AW71/18/HH – 36 Kingsway – Conservation Area – Objection

The most recent plan that I have seen is 602 revision B, dated 4/7/18, shows no pedestrian crossover onto Kingsway, but one is still shown in 601 Rev A, dated 1/7/18, and in the Proposed North Elevation in the Design and Access Development. You cannot have contradictory information on different documents or no-one will know what the proposal really is.

Proposed North Elevation

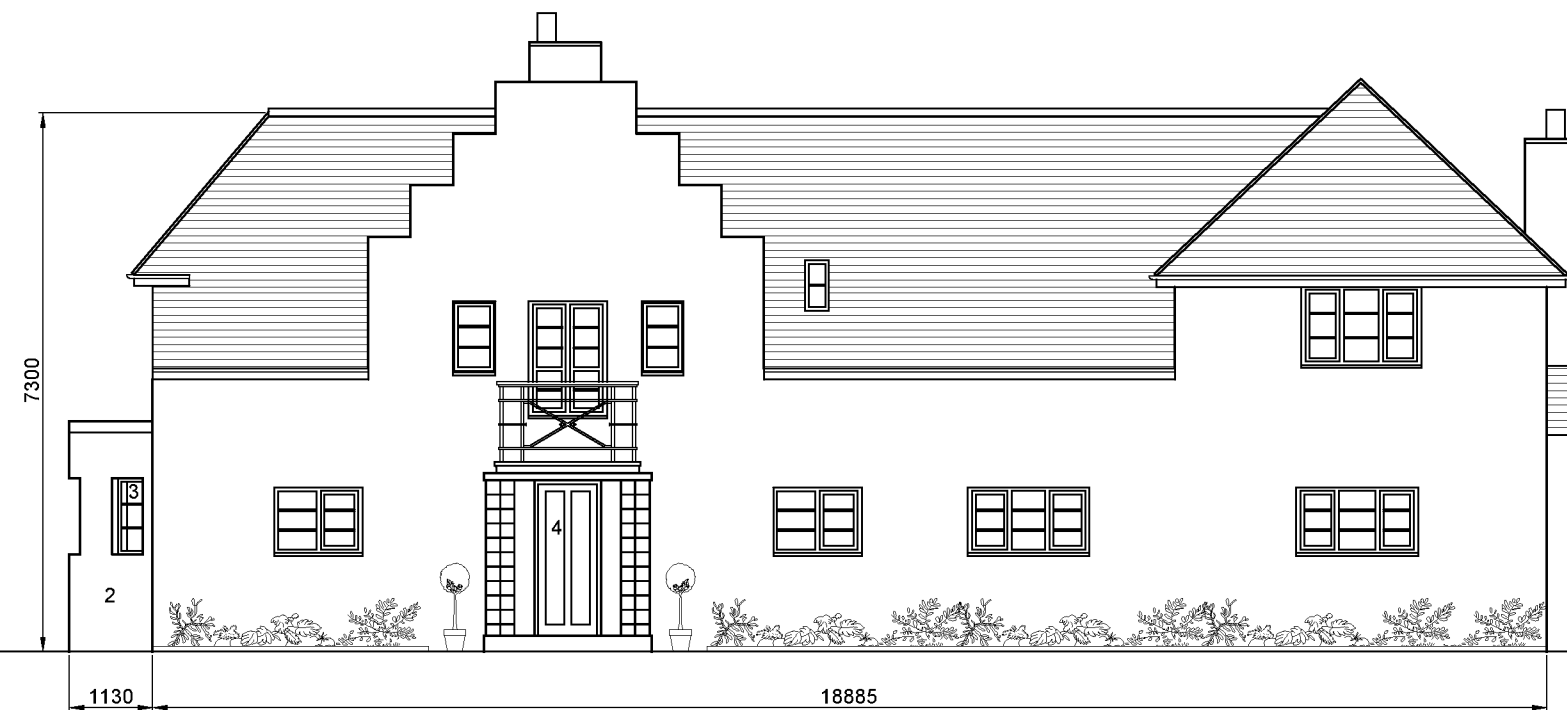
In my letter of the 8th April, point 1, I drew your attention to the fact that the elevations for the present north and east facades, do not correctly show the height of the existing line of trees. What is shown is about half the true height. We have heard much of 'fake news', but of concern here are 'fake plans'. As no substitute drawings have been submitted and for the elimination of doubt I attach a photograph (1) confirming that the house is completely hidden from view in the area of the Kingsway/Queensway junction. This is particularly important for anyone having to take decisions without having seen the property. Please ensure that references to the photograph and the inaccurate elevations are included in your report.

Stafford	01234 281315	0
Woodstock	01304 380600	0
London	020 3002 4141	0
Manchester	0161 552 5777	0
Job No:	E16875	0
Dwg. No:	602	0
Scale:	1:100@A1	0
Drawn:	LB	0
Checked:	MLR	0
Date:	27/02/2016	0
North		0

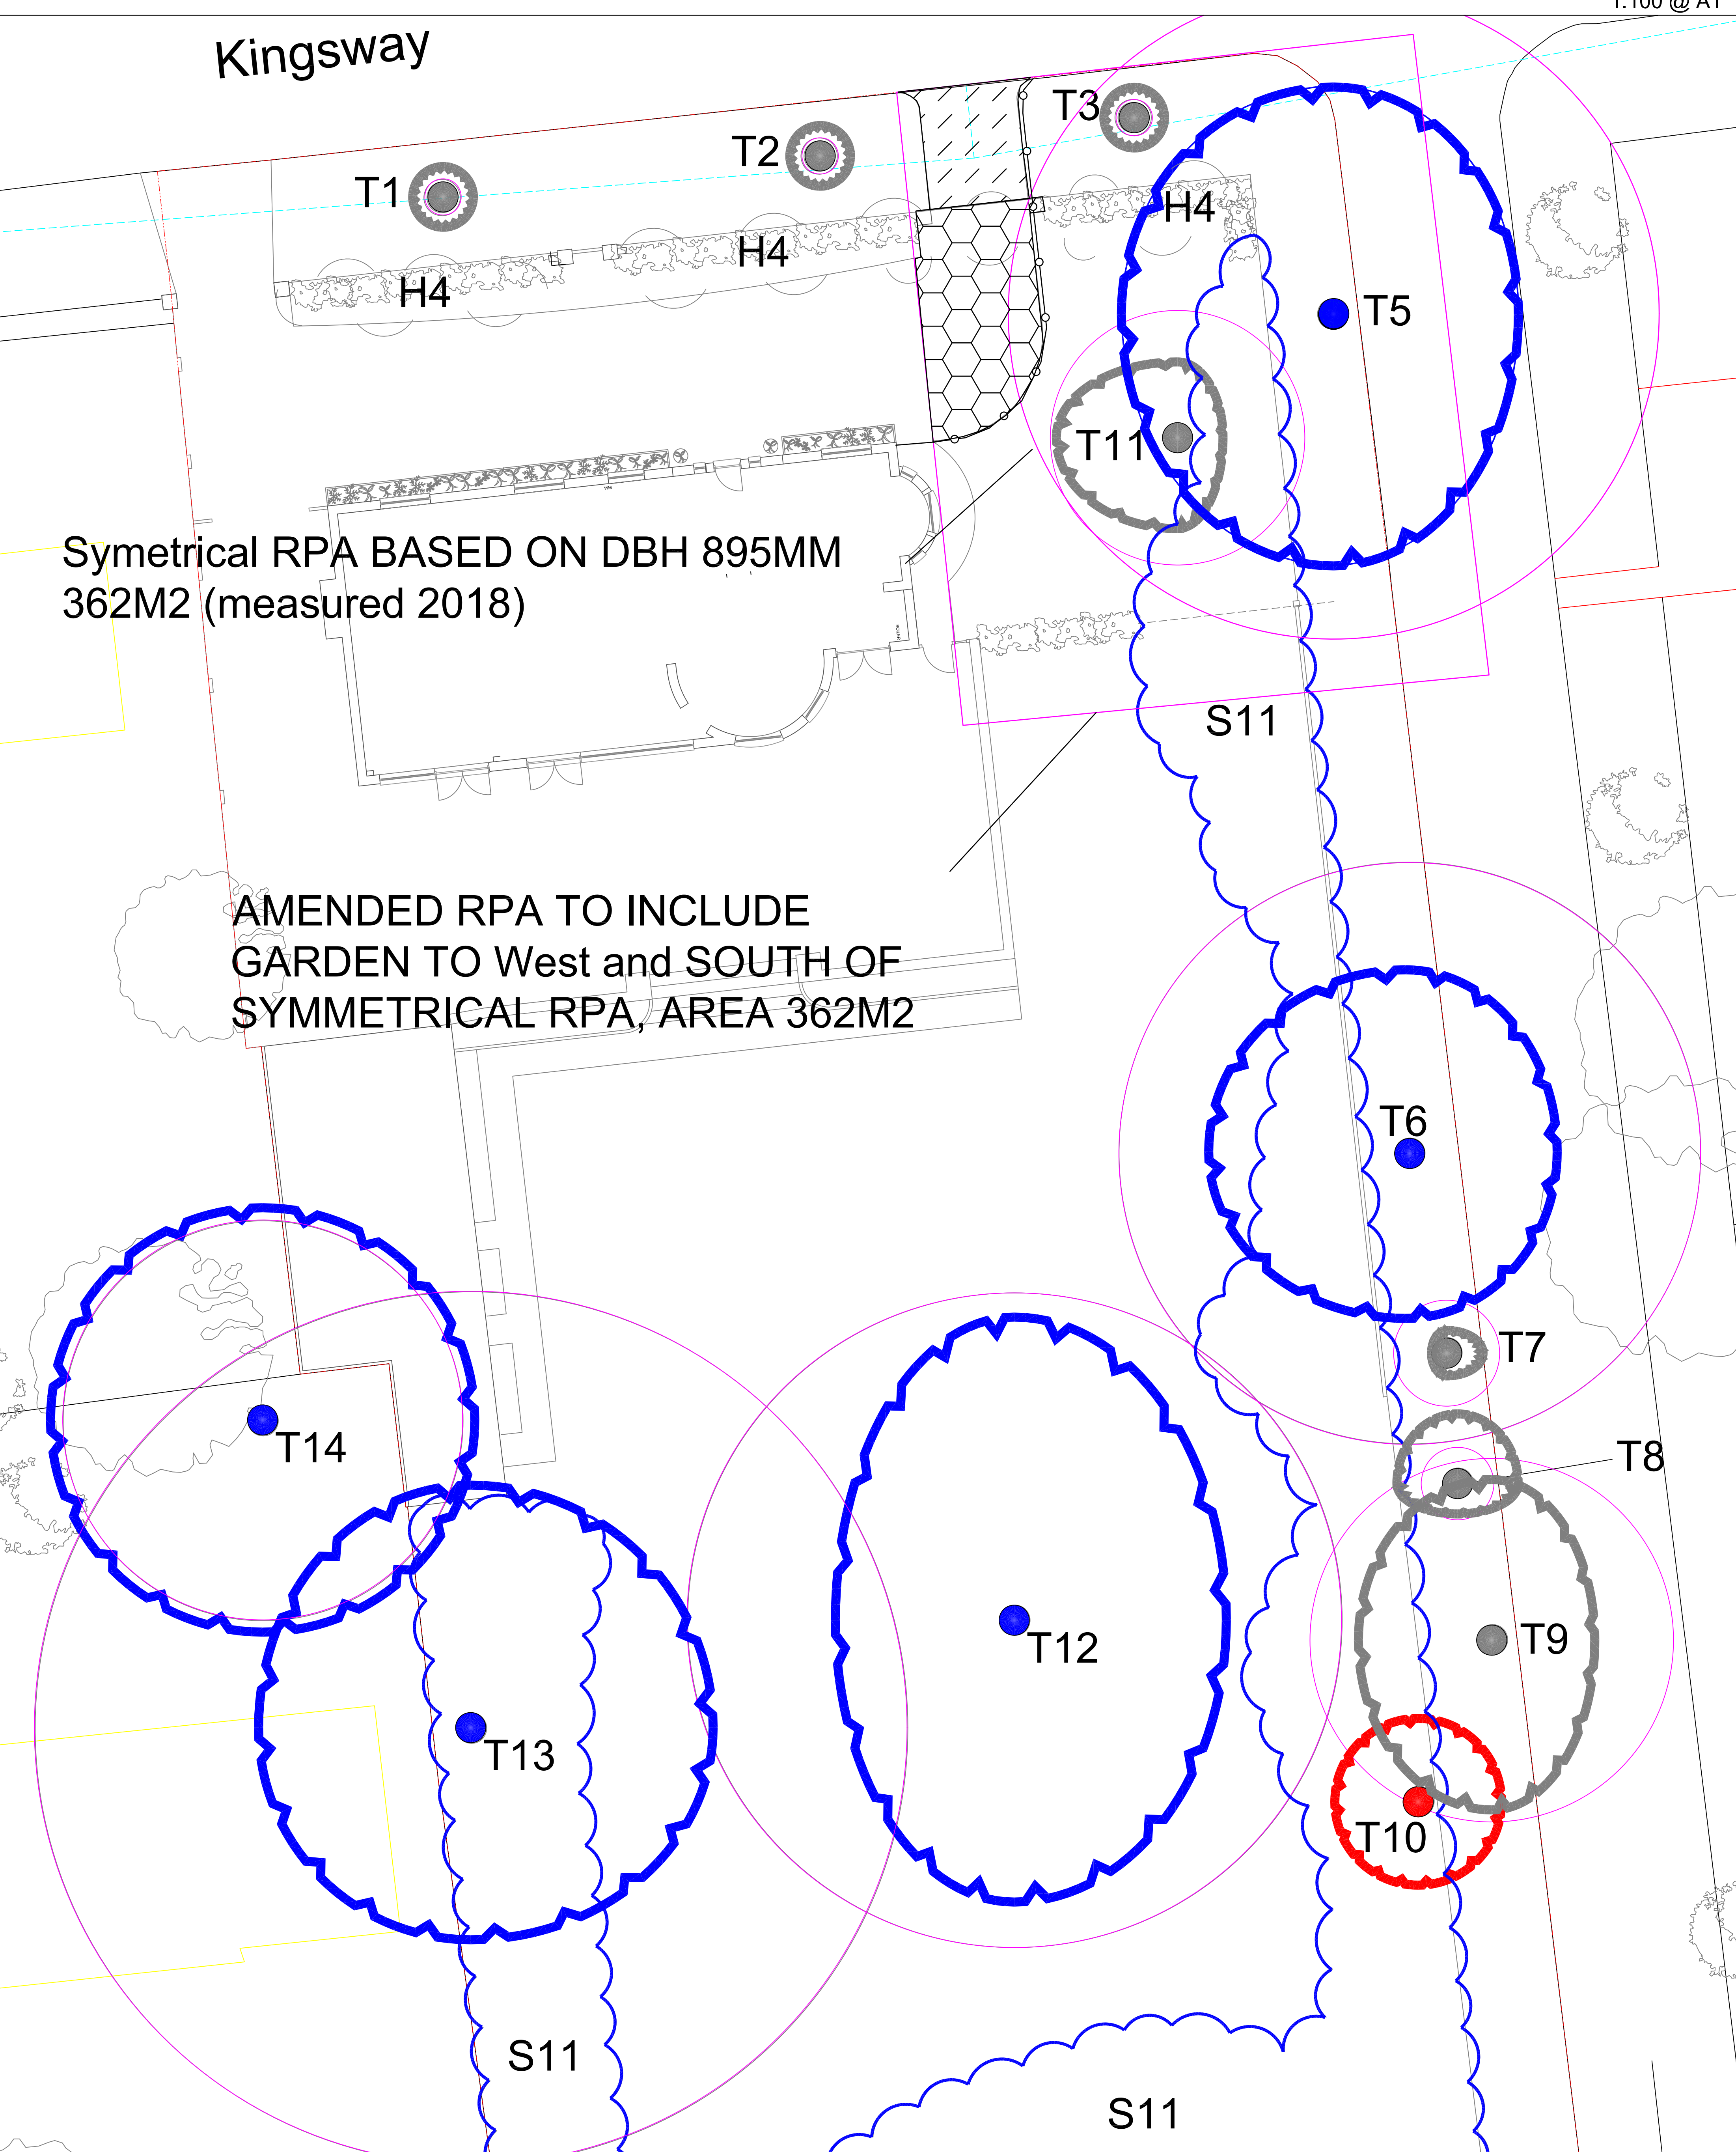
The Tree Officer, quotes the AIA para 6.3 as proposing 'the removal of H4 leyland Cypress, a healthy and established evergreen screen to the front of the property andI leave the relative merit of the proposal to be determined by the planning officer, when considering the wider aesthetic considerations of the development proposal'. In fact para. 6.3 only attempts to justify the removal of the hedge 'to enable the proposed access from Kingsway'. This would involve only the removal of 2 or 3 trees, not the whole row, and is correctly shown in plan 602, rev. B. The remaining trees in the hedge do not impede access from Kingsway.
